East Anglia ONE North (EA1N)  
East Anglia TWO (EA2)  
Offshore Wind Farms  
[Planning Inspectorate References: EN010077 and EN010078]

**Post hearing submission on Issue Specific Hearing 16 (ISH16), Session 2**

Submitted for Deadline 11 (07 June 2021) by

East Anglia ONE North and TWO
Outline Operational Drainage Management Plan
Environment Agency Flood Zones

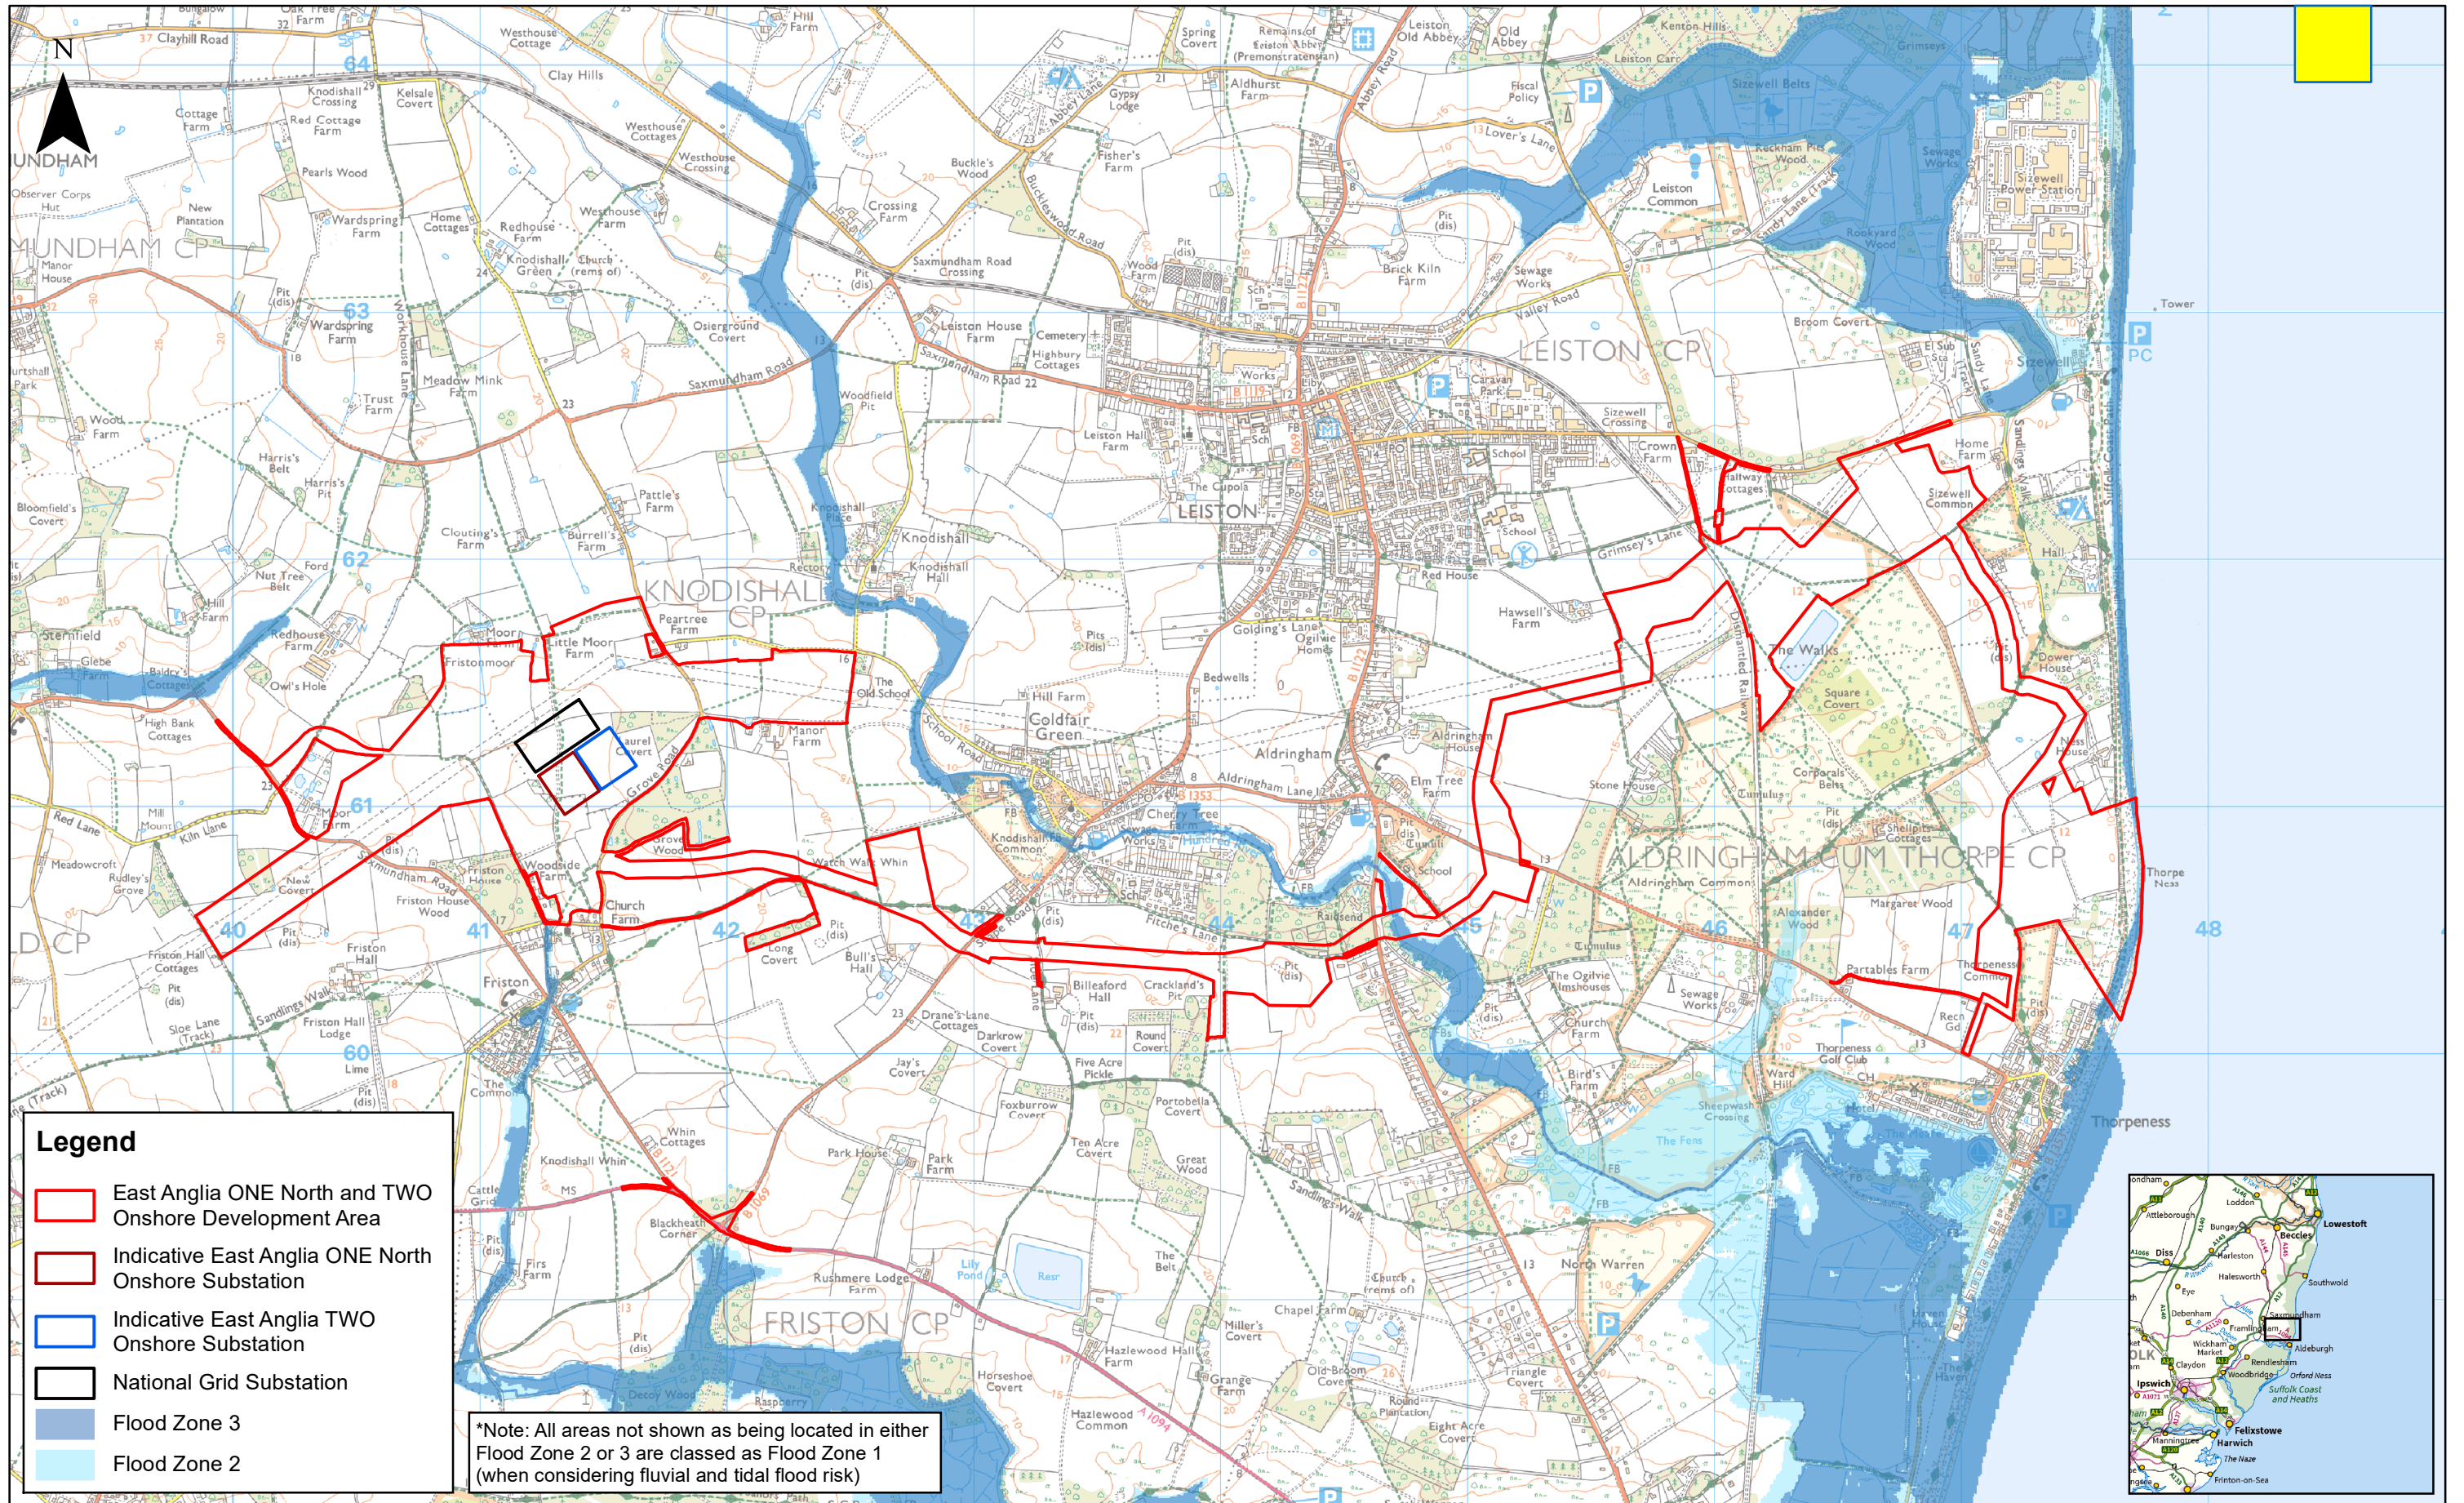
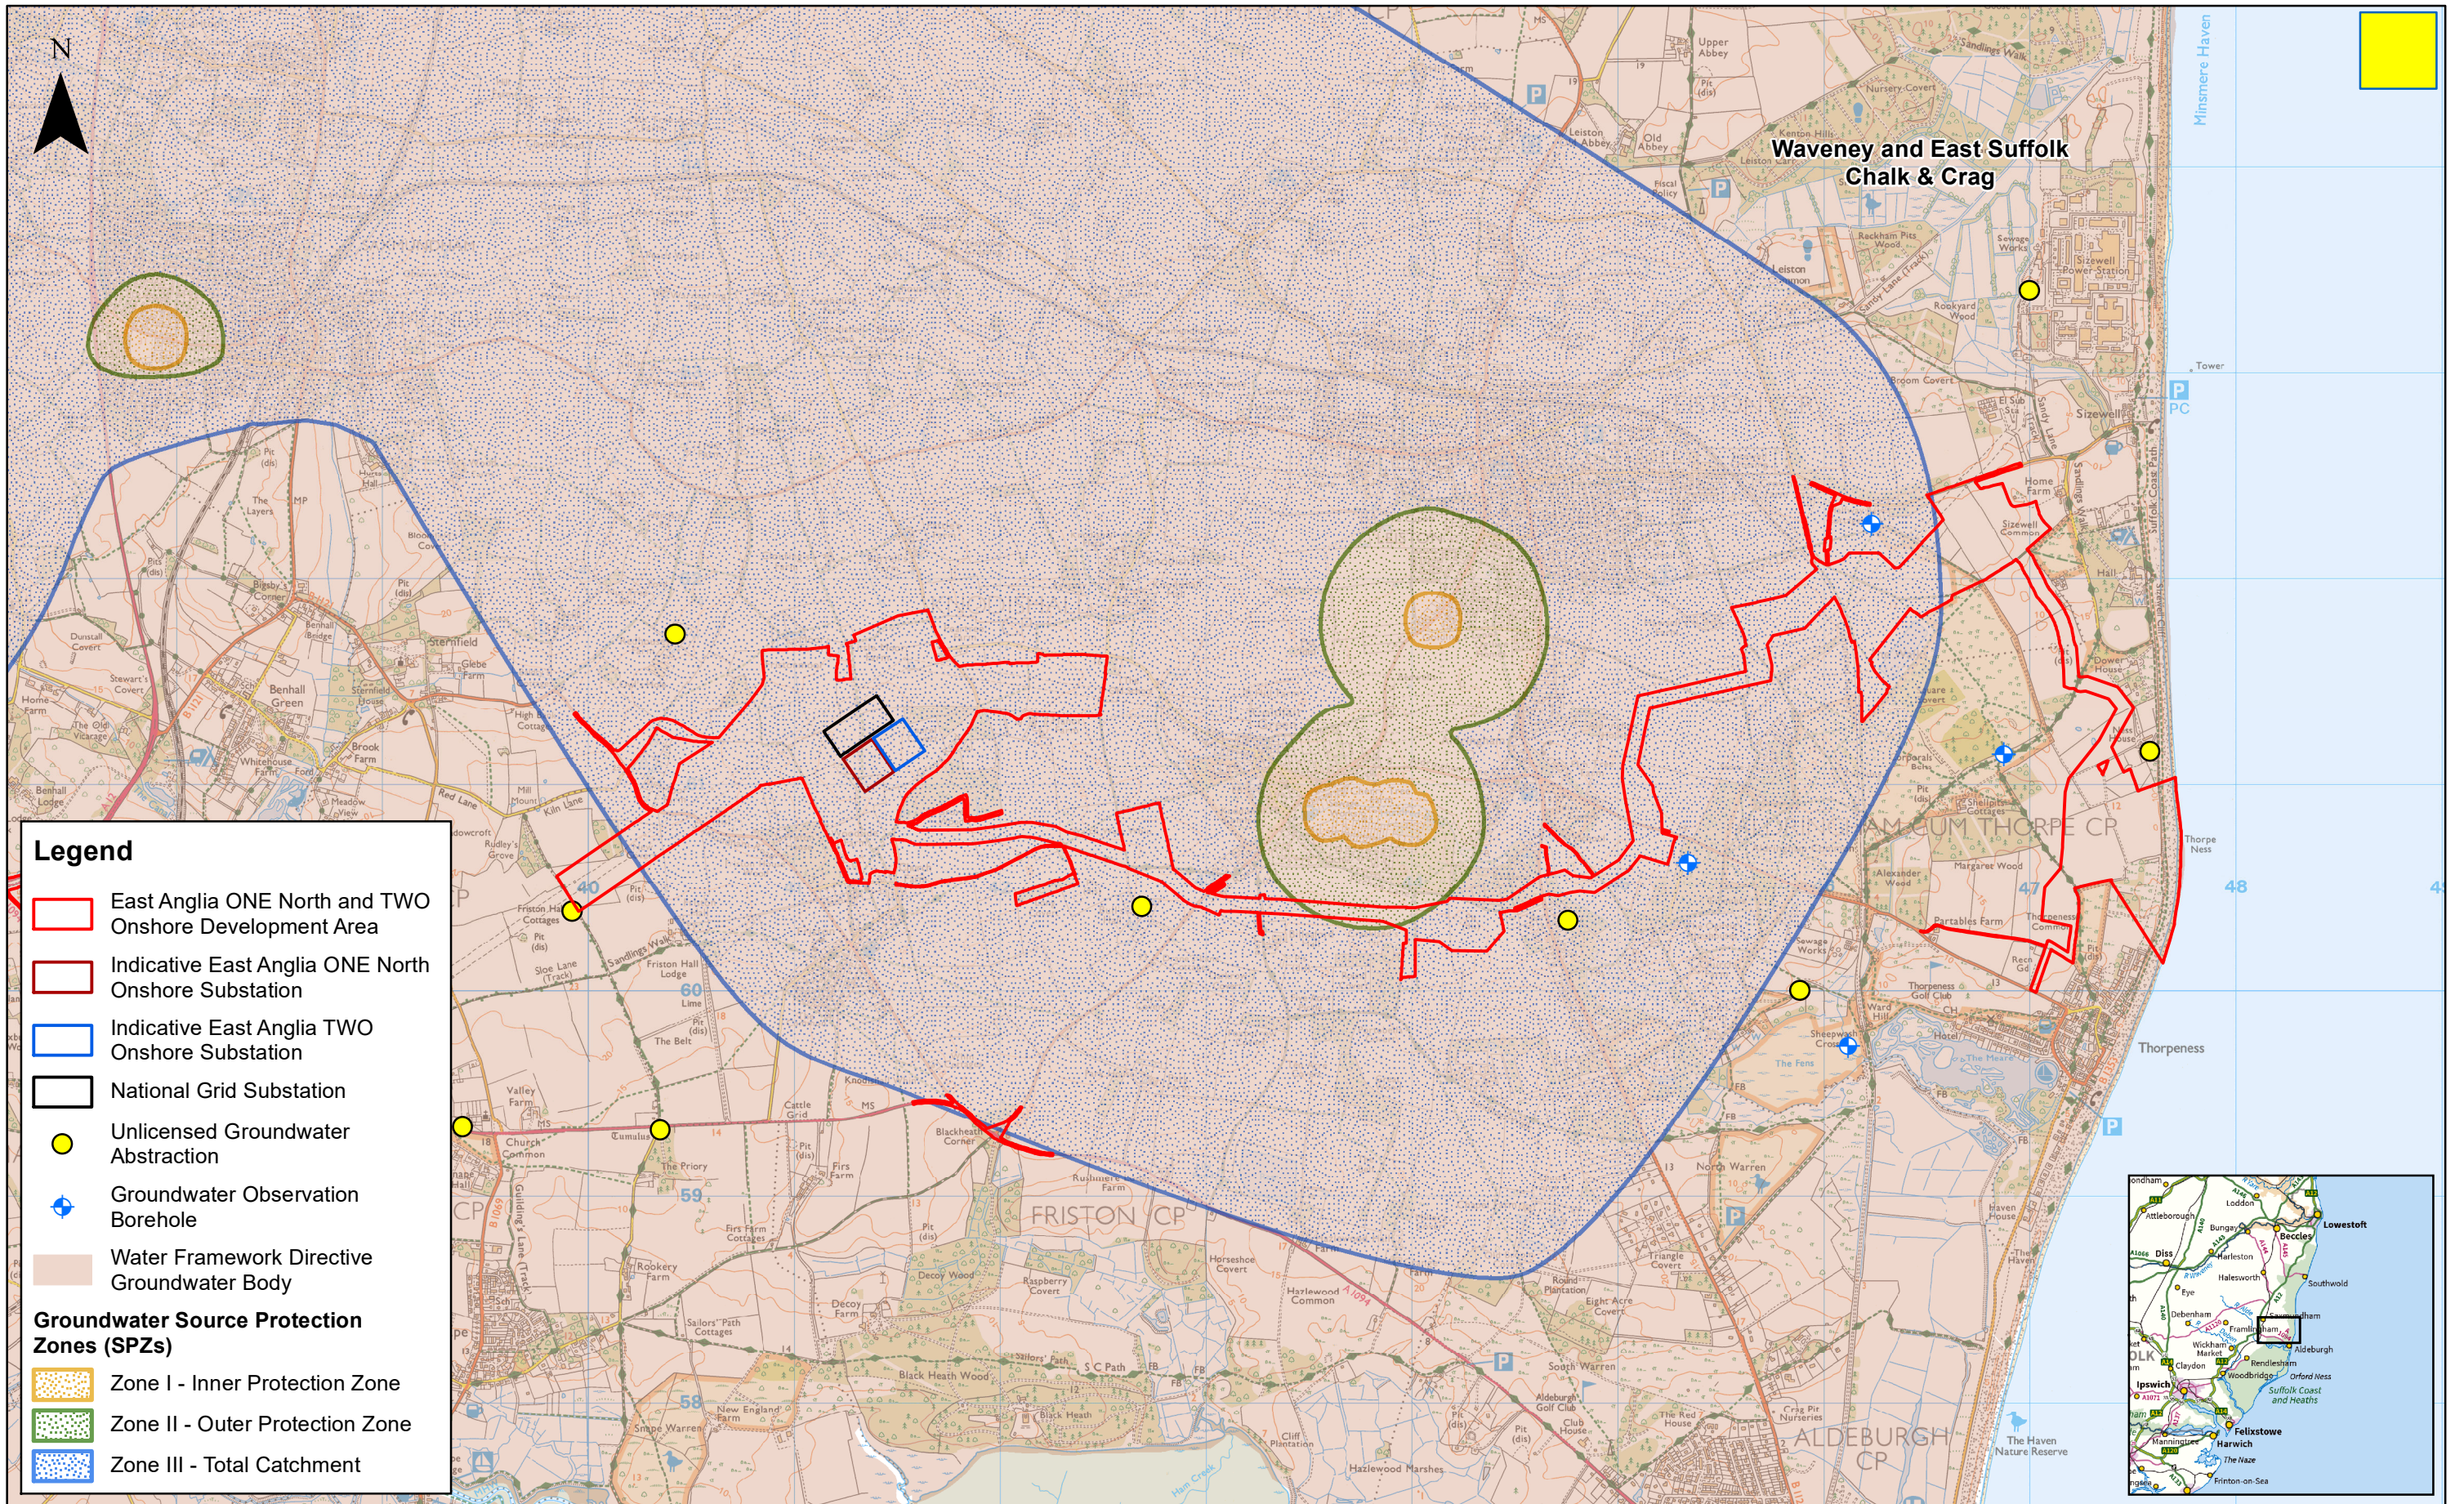
The Applicants have not provided an outline design of surface water management in this Environment Agency designated Risk Category 3 area already suffering inundations of fluvial and surface water flooding. Consequently it appears the Applicants have given no particular thought to mitigation.

We enclose a copy of the Environment Agency Flood Risk Map submitted with our Written Representation at Deadline 1. The level of water in the Hundred River is generally deceptively low. However, following a period of rainfall, the river can overflow its banks and has been known to reach within 10m of properties in Gipsy Lane. There are also believed to be uncharted underground watercourses / aquifers in this area.

We are concerned that the Applicants has not assessed the risk of such flooding being repeated as a consequence of its construction of haul roads etc and from trenching works across the river and in particular at the 16.1m constrained widths:-

- west of the Aldeburgh Road where ground level is **8 m higher than Gipsy Lane** and where old and leaky water mains are installed underground
- along the 50m length of the cable route Order Limits between Aldeburgh Road and the 40m buffer area west of the Hundred River

2. The Example Outline Plan of Surface Water Management Measures requested by ExA at ISH16 should be provided to Suffolk County Council as soon as possible before Deadline 12 and should address the Cable Route Section(s) within Works Nos 19 and 20 that includes the Aldringham River Hundred Area and land within 125 metres to east and west of the river. That would seem to us to be the most complex area in this respect along the entire cable route and also is the section already most subject to surface water flooding. It should take account of the topography and relative elevation / altitude of the land at appropriate points within the Order Limits and potentially affected properties within 150m to the south-east of the order limits in Gipsy Lane.
